PLANNING CONSULTATION RESPONSE

Application No	2026/0257
Proposal	Removal of existing septic tank and installation of package waste treatment plant with drainage field.
Address	Norfield House, Bank End Lane, High Hoyland, Barnsley, S75 4BB
Date of Consultation Reply	24/06/2026
Consultee	Katie Lawrence, Planning Ecologist

Project 2603-004	Sheet
Date 24.06.2026	A1
Scale As Noted

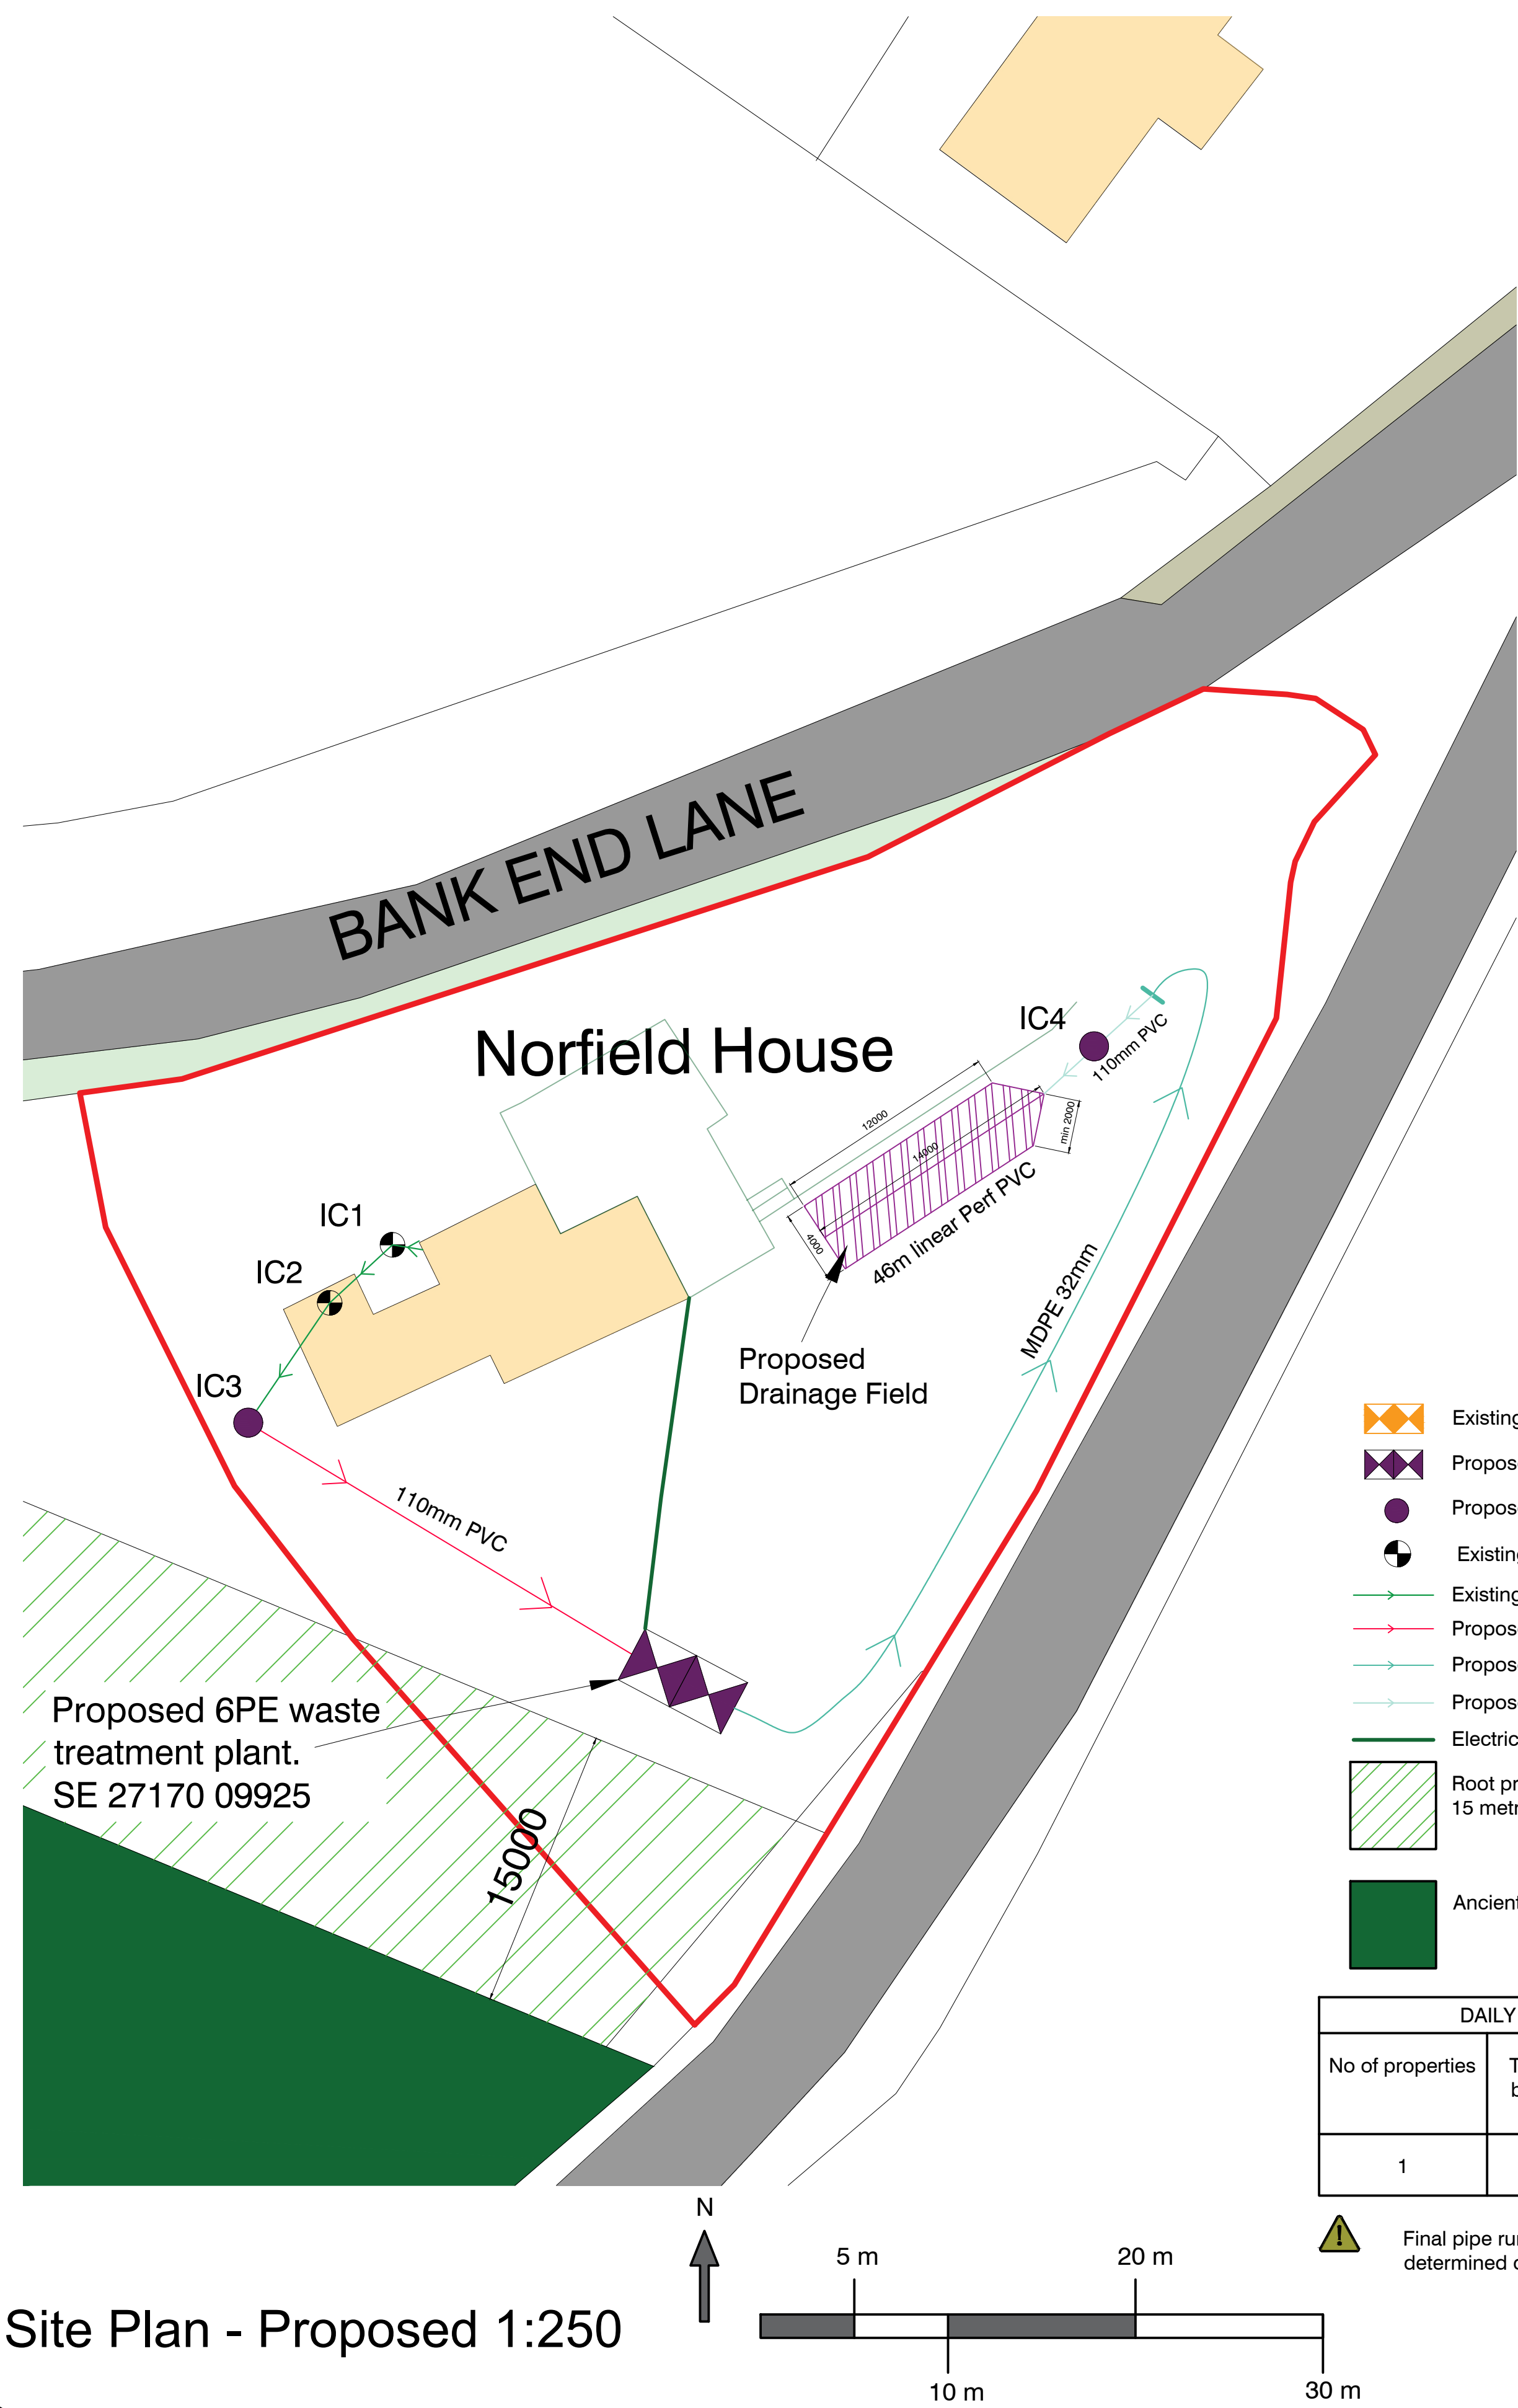
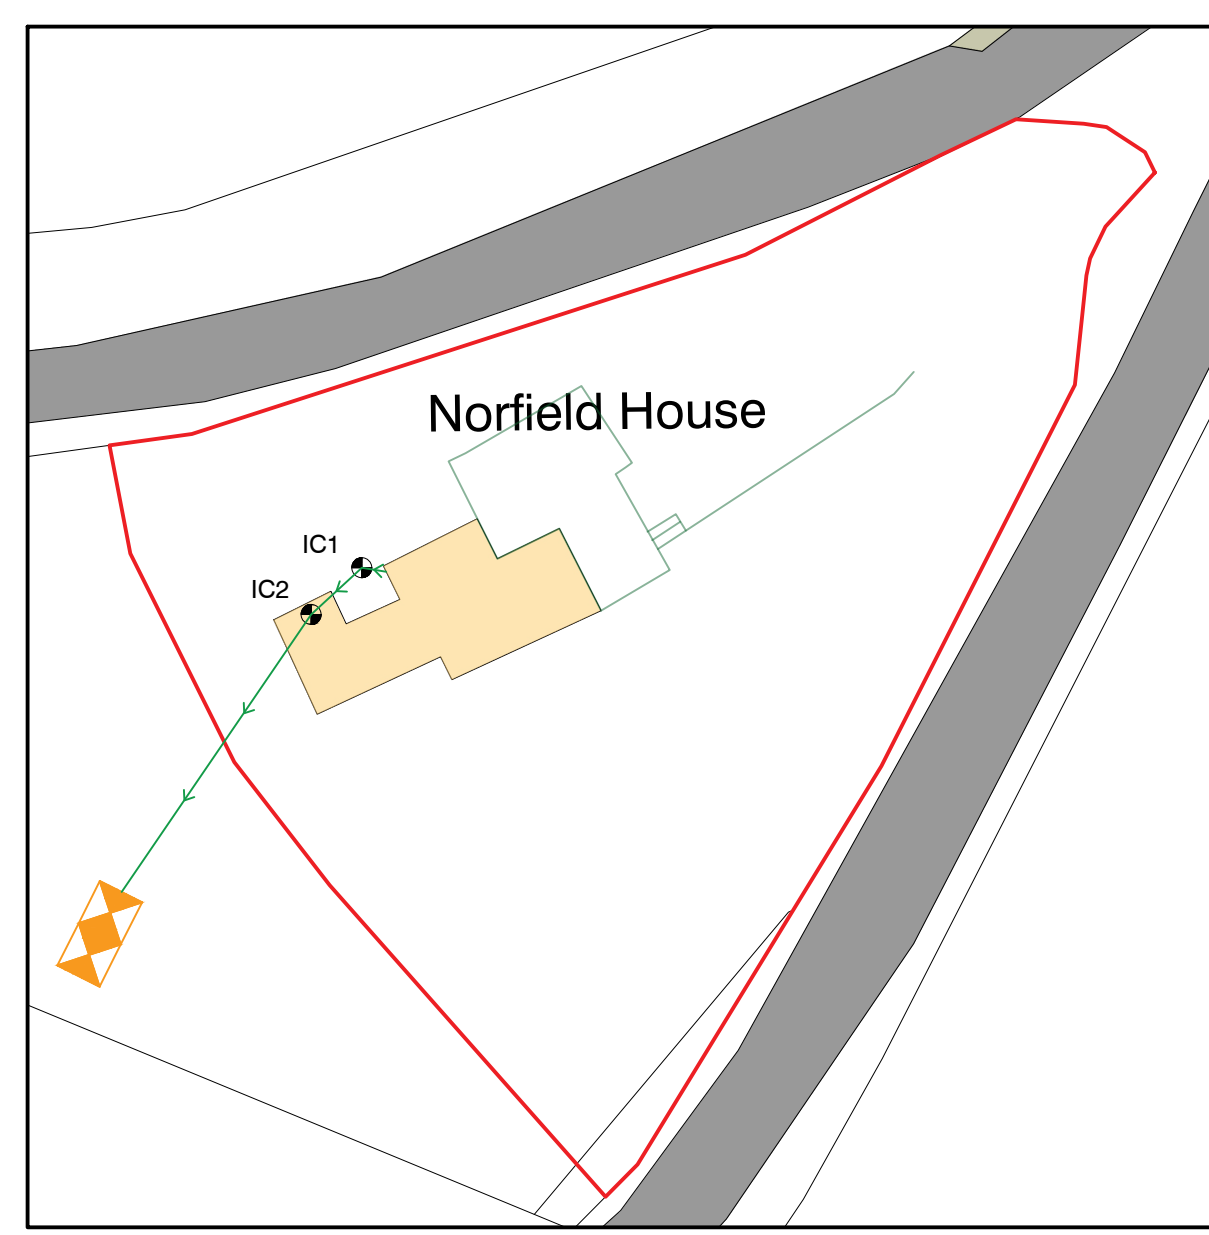
Thank you for providing an updated plan which indicates the revised location of the waste treatment plant. The treatment plant is now located over 15m from the area of ancient woodland which occurs adjacent to the south-west of the site as per government guidance, which is welcomed.

A condition regarding tree protection should be applied to protect the 15m buffer zone from the boundary of the ancient woodland to prevent encroachment or the storage of building materials within this area during construction works.

The development shall be completed in strict accordance with the plan titled New Waste Water Treatment Plan (drawing no. 2603-004, 24.06.2026).
